CITY OF ALBUQUERQUE

July 11, 2018

Re: TCL Warehouse, 5000 Edith Blvd NE
Request for Certificate of Occupancy
Transportation Development Final Inspection
Architect's Stamp dated 02-17-18 (G15-D032)
Certification dated 06-28-18

SITE PLAN

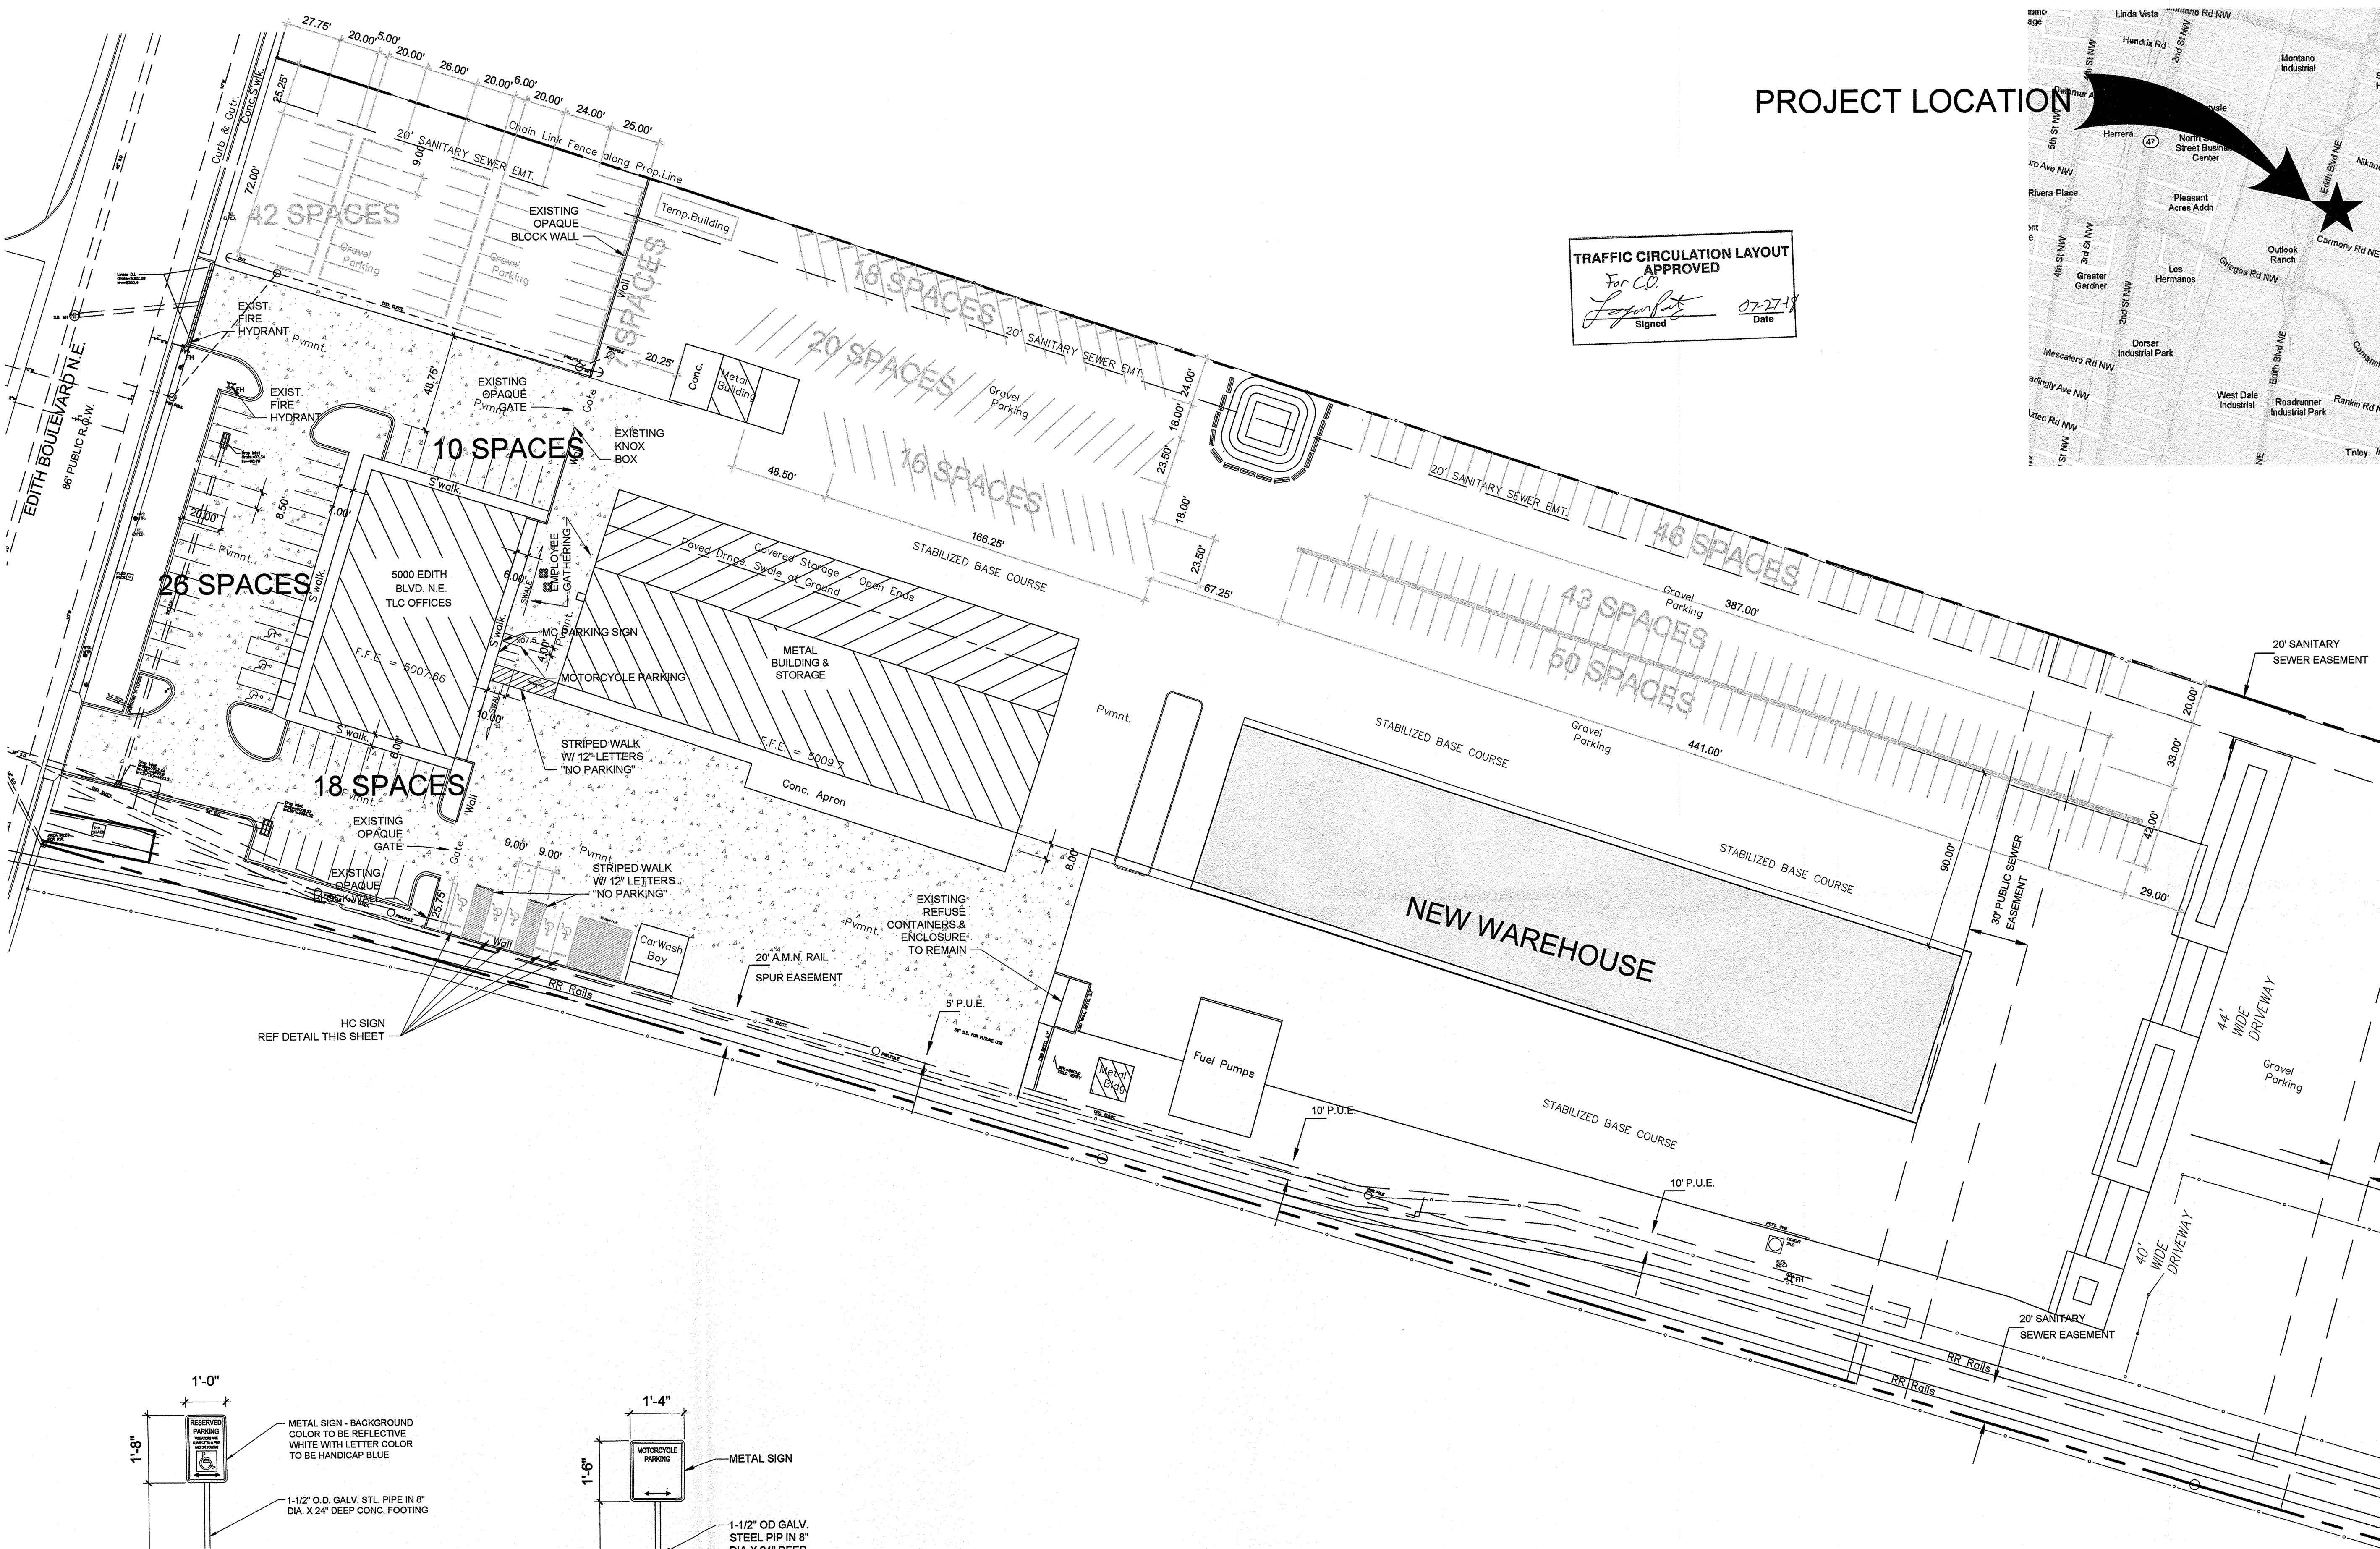
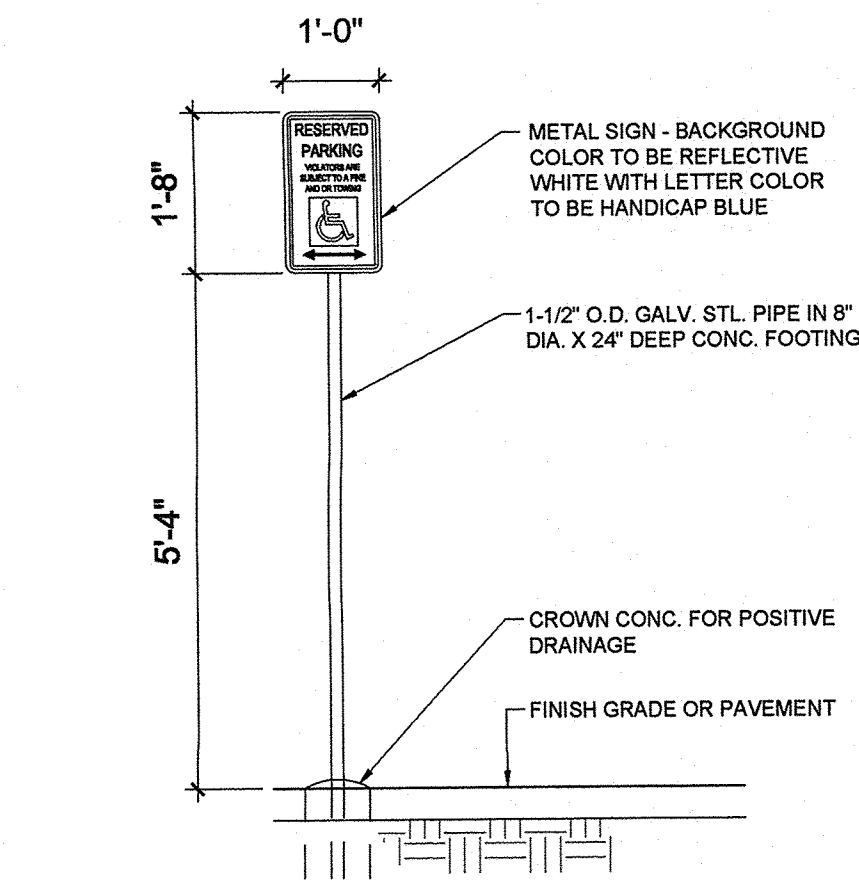
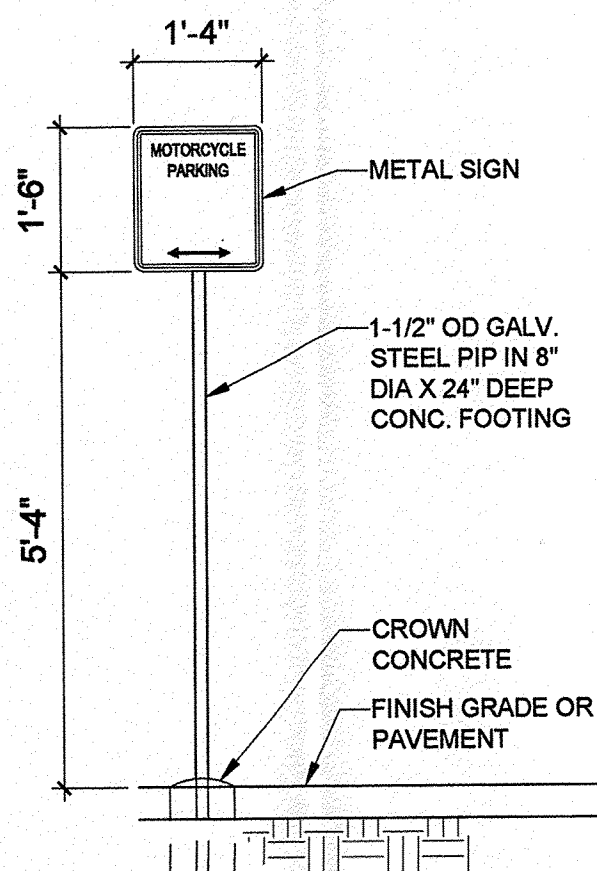
- The TCL does not match the approved TCL Architect stamp date 02/17/17. A revised TCL that reflects the existing and new site conditions must be submitted for review and approval.

- All ADA accessible parking sign must have the required language per 66-7-352.4C NMSA 1978 **"Violators Are Subject to a Fine and/or Towing."**
- The ADA access aisles shall have the words **"NO PARKING"** in capital letters, each of which shall be at least one foot high and at least two inches wide, placed at the rear of the parking space so as to be close to where an adjacent vehicle's rear tire would be placed. (66-1-4.1.B NMSA 1978)
- Motorcycle parking spaces shall be designated by its own conspicuously posted upright sign, either free-standing or wall mounted.
